**REQUEST**

Proposed Zoning: RAC(EX) (regional activity center, exception)

Approximately 15.98 acres located along the north side of Rexford Road, south of Wickersham Road, and west of Colony Road.

The petition proposes a mixed-use development including multi-family, office, and retail uses on a site that is currently developed with two office buildings.

STREET SECTION 1

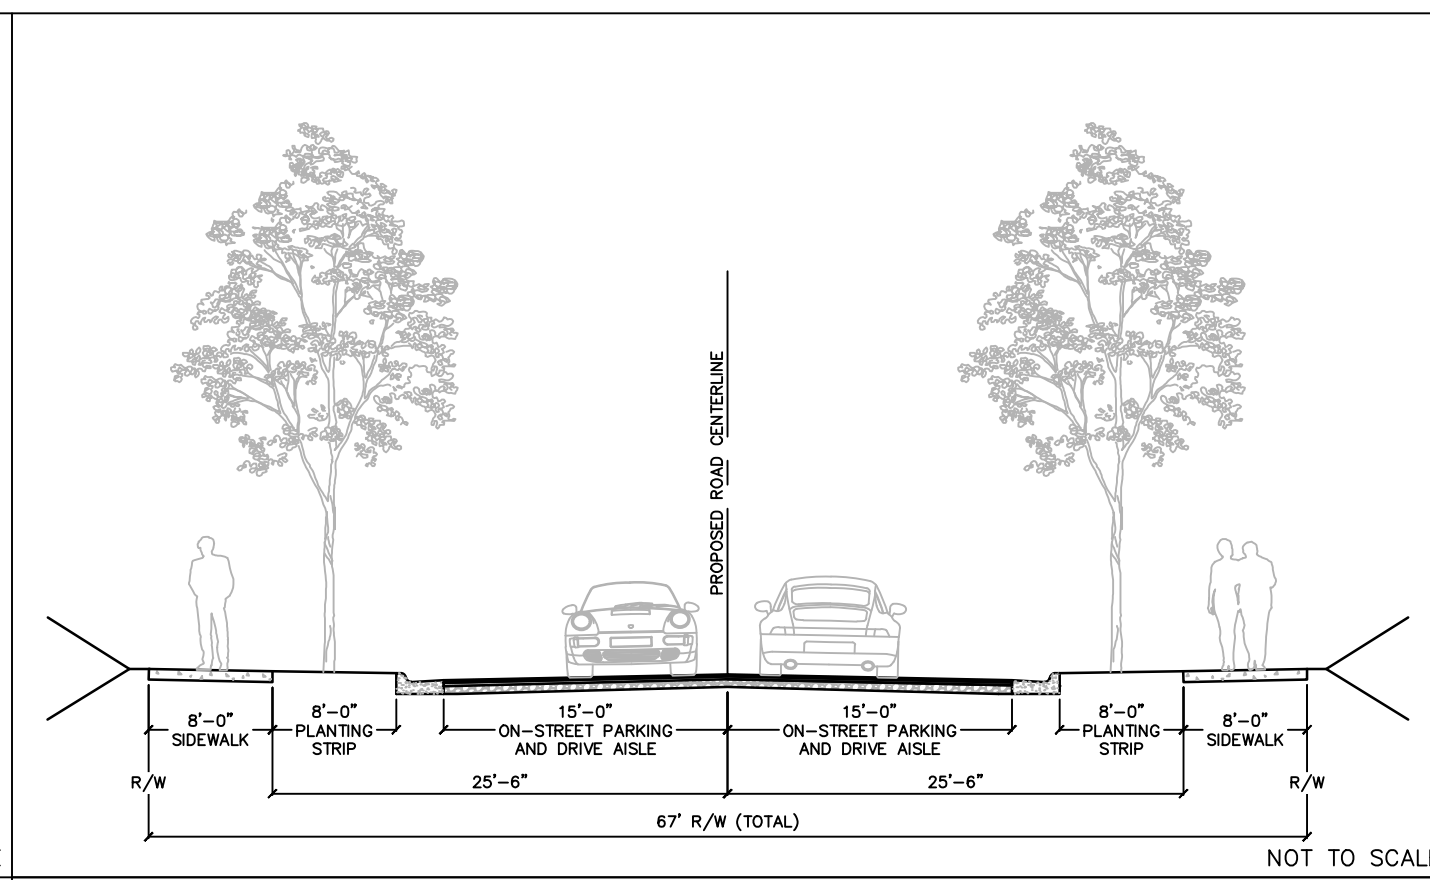
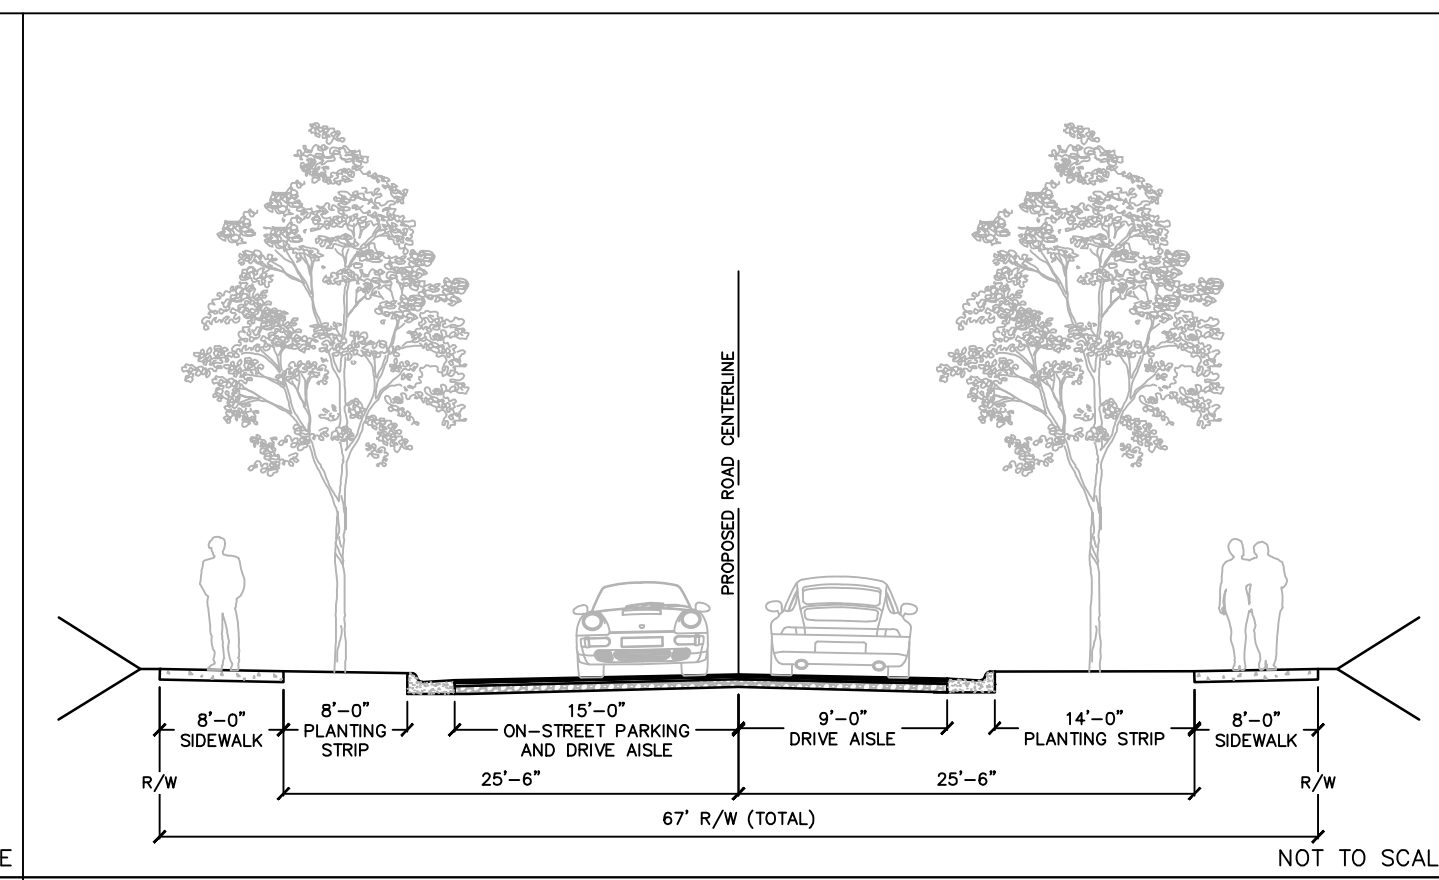
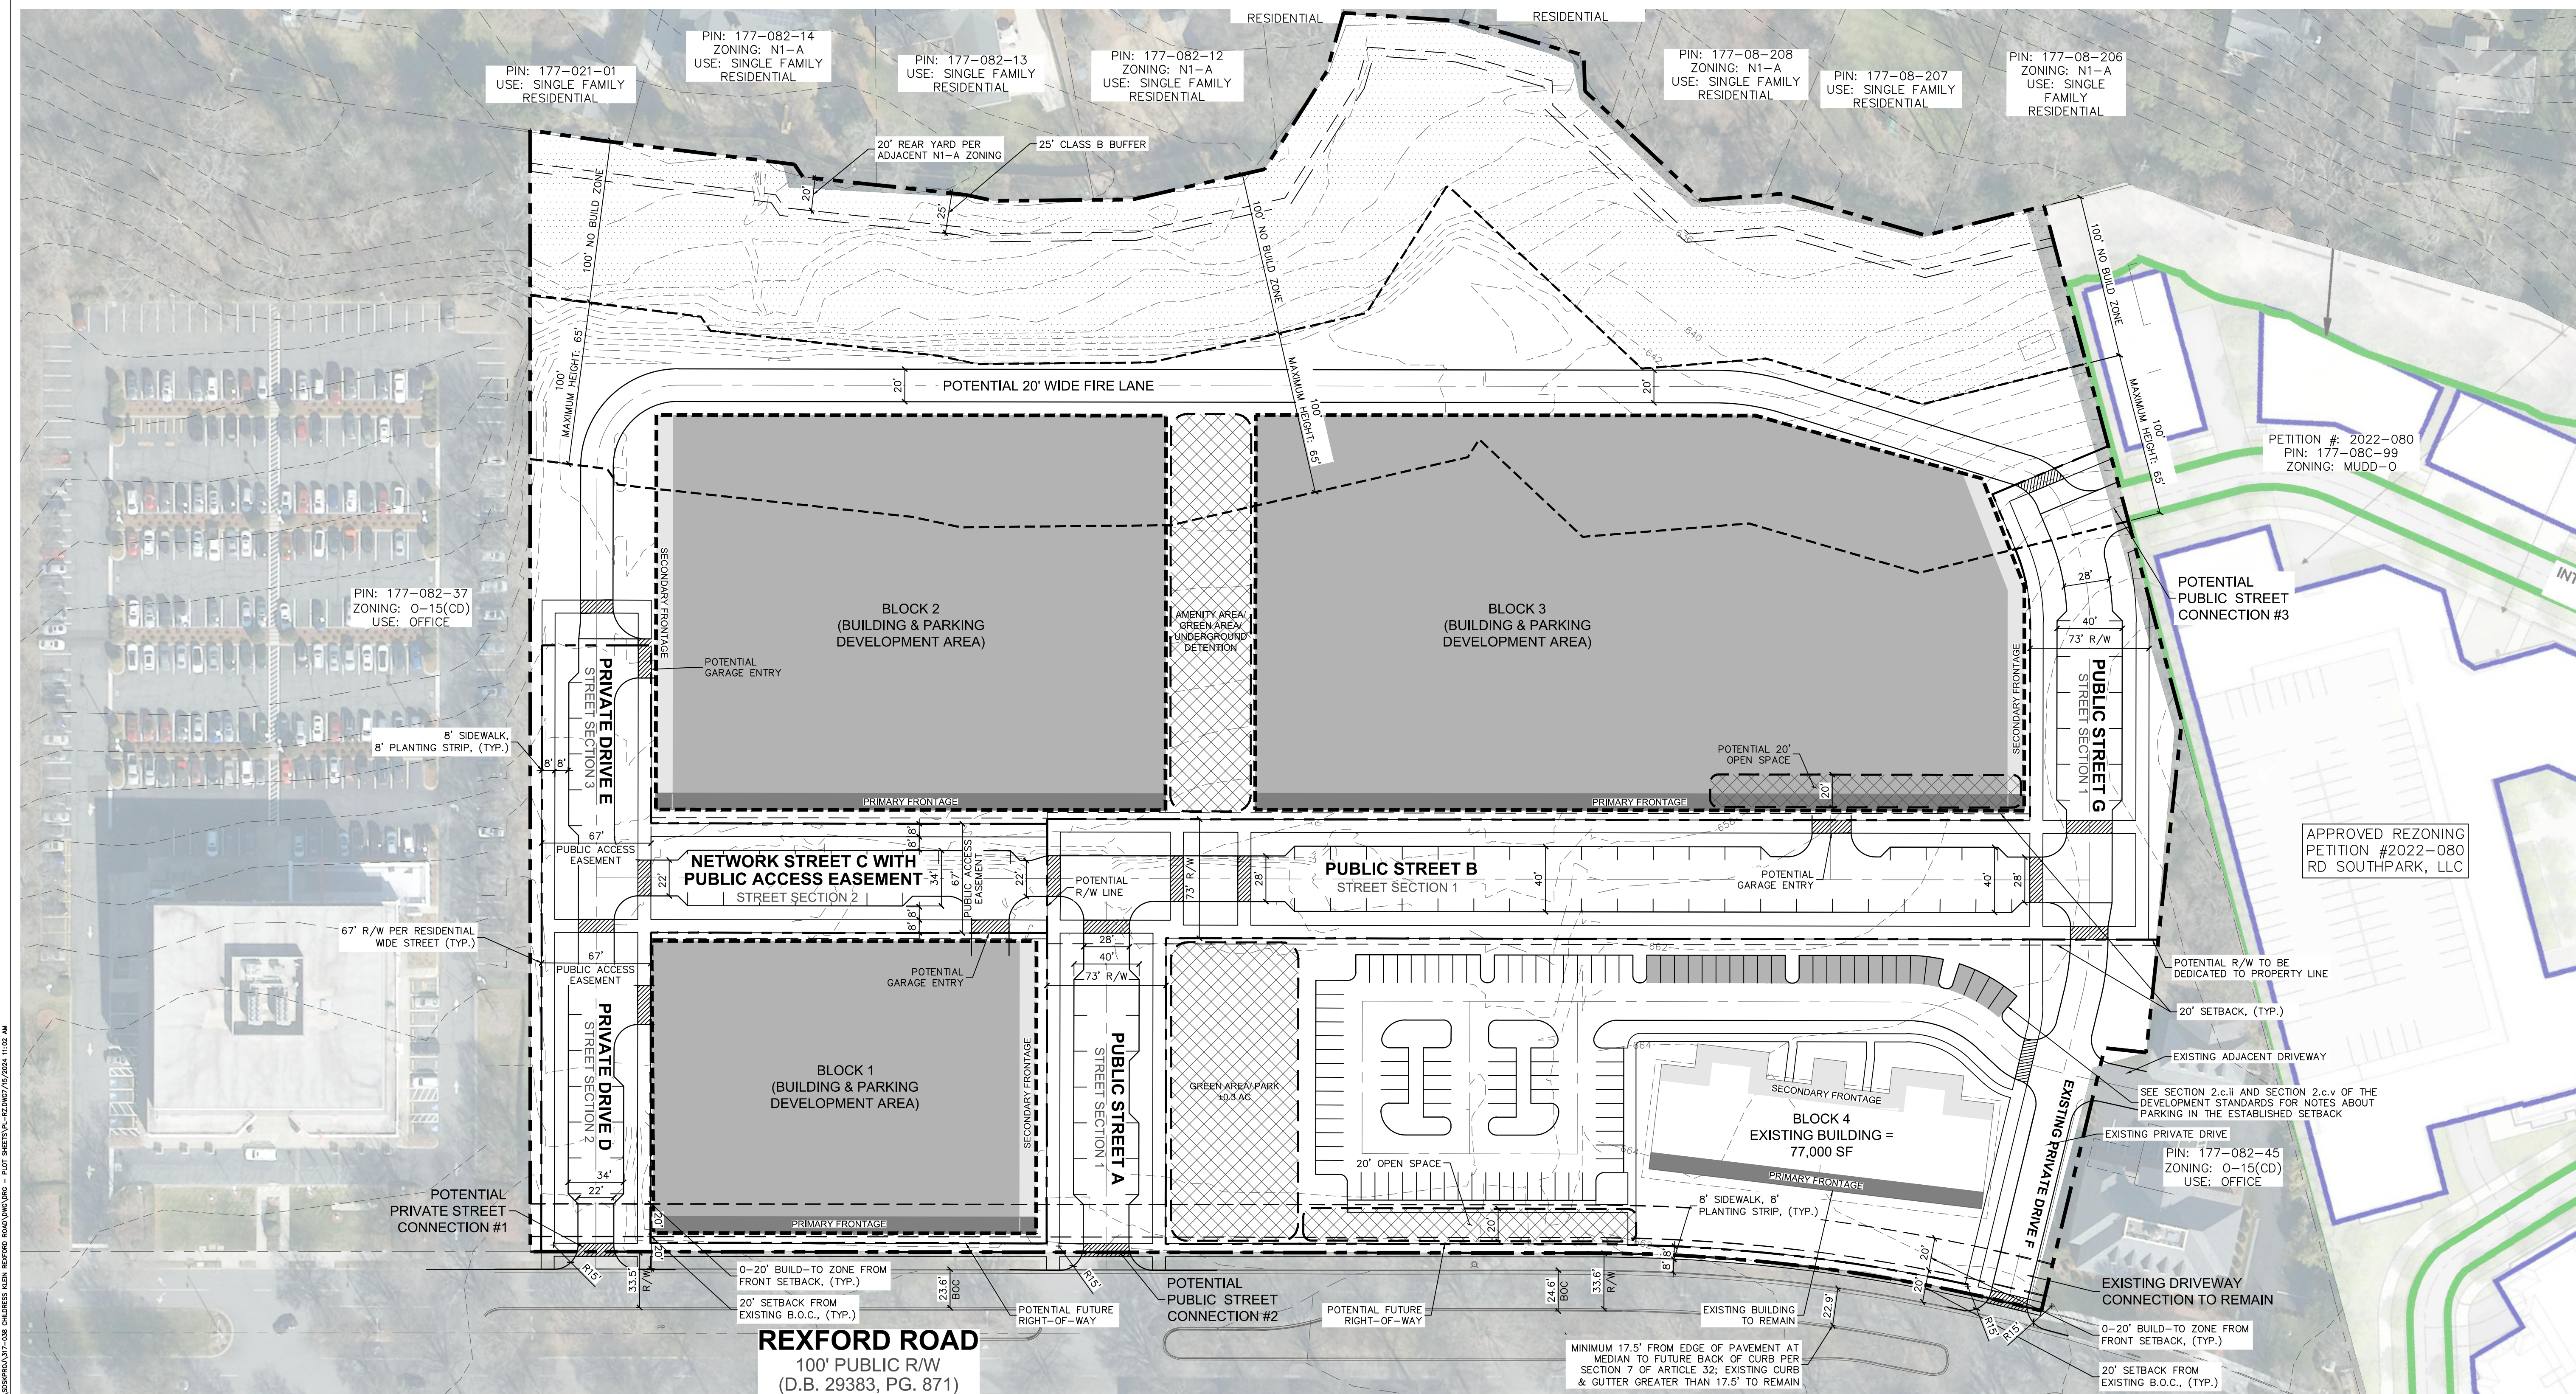
1. CDOT: Rexford Road: The future back of curb location is 20.5' from road centerline. CLDSM U-05A1 Local / Office Commercial Wide Street Typical Section (8' Sidewalk). Label and dimension the curb and gutter from the centerline for each road on the site plan.

2. CDOT: Revise site plan to utilize commercial / office wide street sections for the public roads. Per UDO article 33, all non-residential development within the Regional Activity Center place type must utilize office / commercial wide street sections. Please revise street section shown below and update plans to reflect CLDSM U-05A1. CDOT does not accept residential wide street sections as part of the requested exception.

3. CDOT: Revise site plan to remove parking from driveway stems. Per Charlotte Streets Manual, a 100' minimum length is required for channelization.
4. CDOT: Revise site plan to include necessary ADA on-street parking spaces. Per PROWAG R211, 4 accessible spaces are required per 76-100 on-street parking spaces.

5. CDOT: Revise site plan revisions to remove all unsignalized crosswalks from plans. Discussion regarding crosswalks can take place during project permitting.

6. CDOT: Request site plan revisions to commit to installing 8' planting strip and 12' shared use path along Rexford Road as part of The LOOP. Specifications for materials to be provided during permitting.

7. CDOT: Request site plan revisions to include pedestrian crossing and refuge at the midpoint between intersection to the east and existing pedestrian ramps to the west.
